## REFUSAL OF PLANNING PERMISSION

APPLICATION NO. 2015/0489

**Proposal Erection of single storey front extension to dwelling  
At 41 St Michaels Avenue, Monk Bretton, Barnsley, S71 2SD**

Revisions	A. A----	00-00-00
This drawing is for planning permission only and is not a construction drawing.		
Drawing Title	PROPOSED-ELEVATION	
Job No. - Dwg No.	GP/2015/5	-

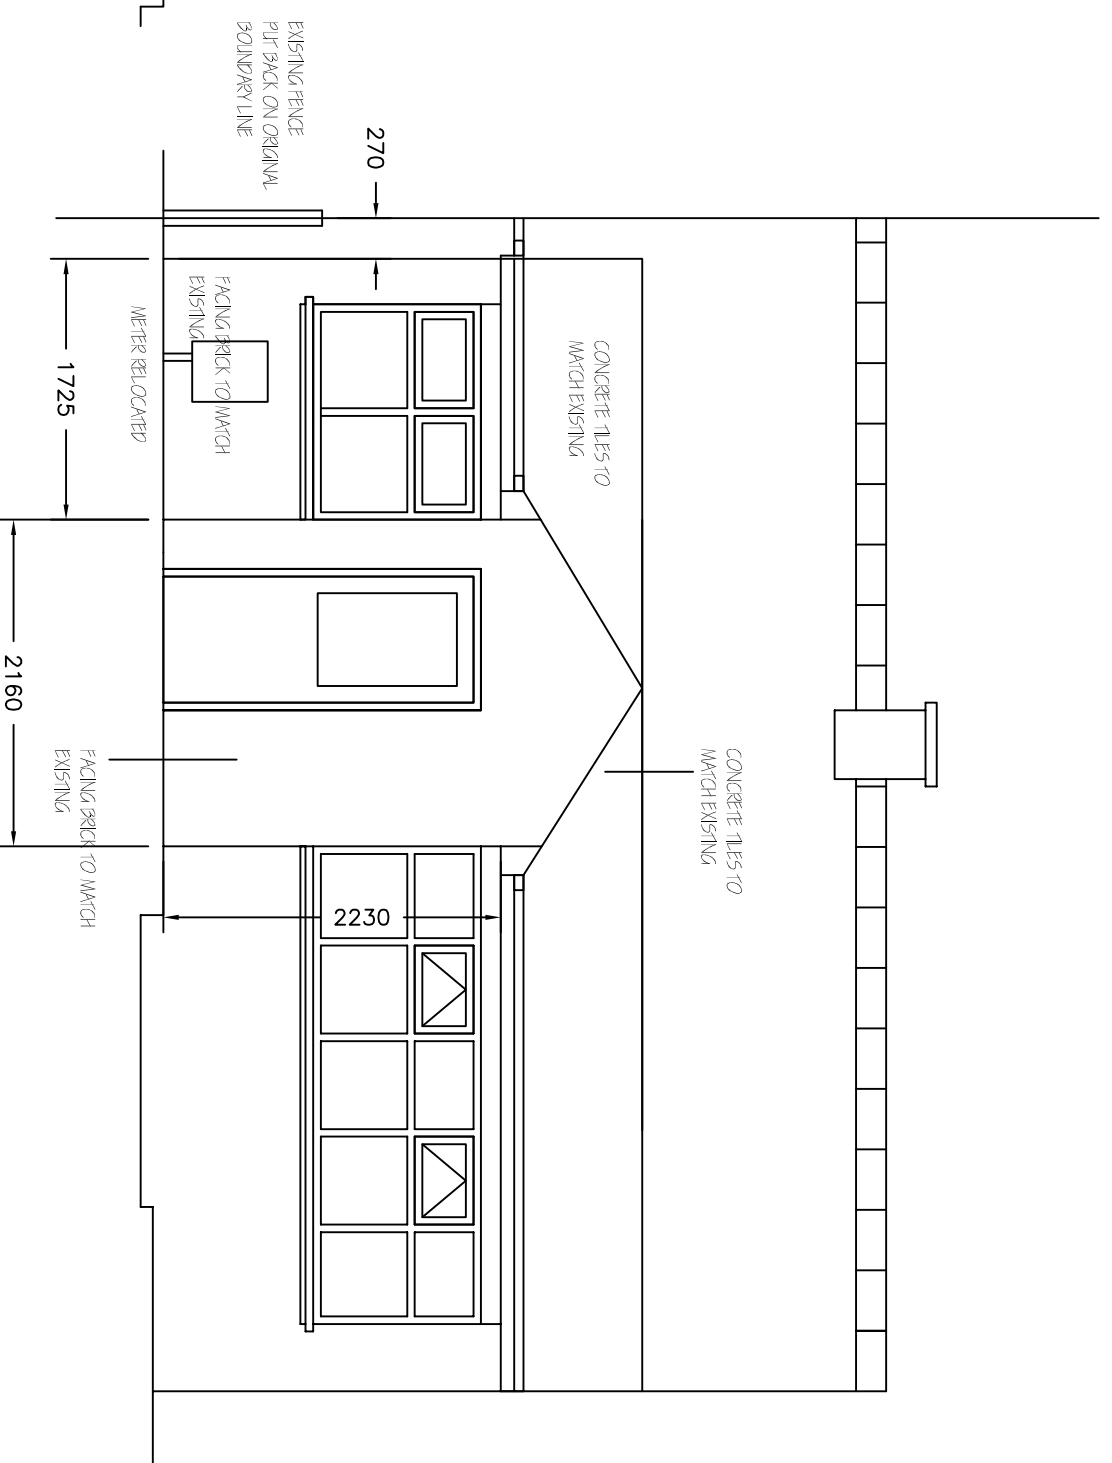
- 1 The proposed porch would effectively be an extension to a front extension which is not characteristic of, and would therefore detract from, the street scene, and taken together with the existing and proposed front extension would overwhelm the modest original dwelling in an unsympathetic manner contrary to CS Policy CSP29, the relevant planning policy statements in the NPPF relating to requiring good design and the Council's SPD - House Extensions.
